**REQUEST**

Current Zoning: TOD-TR (transit-oriented development – transition)  
 Proposed Zoning: CG(CD) (general commercial, conditional)

Approximately 0.776 acres located at the northeast intersection of South Boulevard and Starmount Cove Lane, east of England Street.

The petition proposes the development of a financial institution with accessory drive-through lane. The site is currently developed with a retail building.

RZ01 - REZONING PLAN

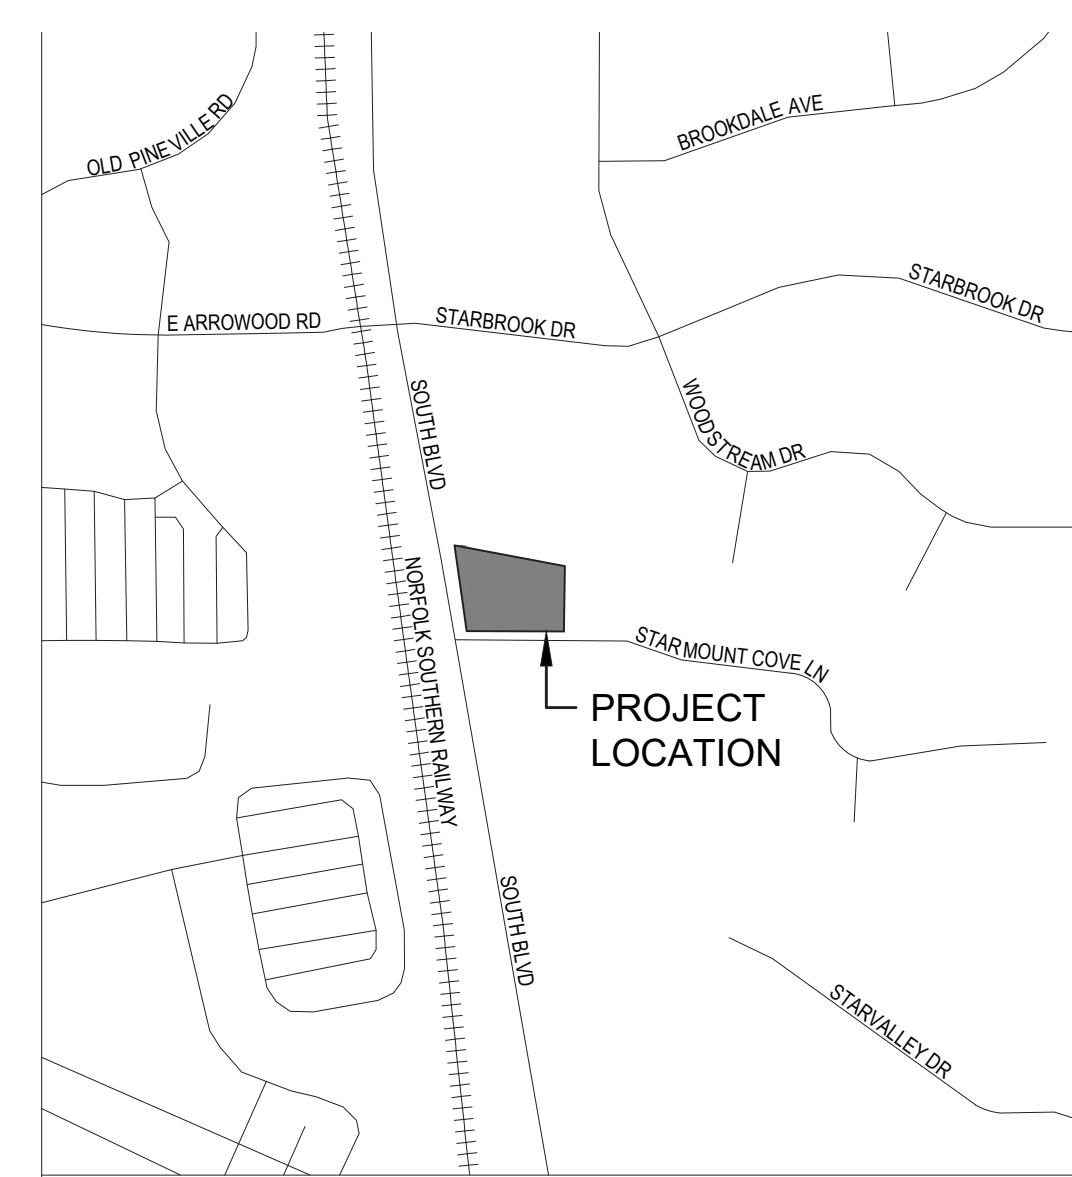
4. ~~Reorient the building to front on South Blvd and Starmount Cove Ln and push the parking and drive-through facilities fully to the side and rear of the building. Addressed~~
5. ~~Meet all applicable prescribed conditions for accessory drive-throughs located in Activity Center Place Types rather than Commercial Place Types to better align with the 2040 Policy Map. Addressed~~
6. ~~Remove parking and maneuvering areas from between the building and frontage. This allows the setback requirement to be reduced to CAC-1 standards. Addressed~~
7. ~~Remove the driveway access to South Blvd to enhance pedestrian facilities.~~
8. ~~Add architectural standards to the plan that comply with the TOD-TR zoning district and the Community Activity Center Place Type. Addressed~~

9. ~~Entitlement Services: A prominent entrance is required on the Starmount Cove facing façade per table 6-6 of the UDO. Addressed~~

10. ~~Calculations of parking provided are incorrect. 8 parking spaces shown on plan, data table states 11 are provided. Addressed~~

11. Entitlement Services: Eliminate parking spaces that are closer to South Blvd than the front façade of the building.
-

- The petitioner has revised the plans to remove parking and maneuvering area from between the building and the street frontages.
    - This creates an uninterrupted pedestrian environment from South Blvd to the entrance of the building.
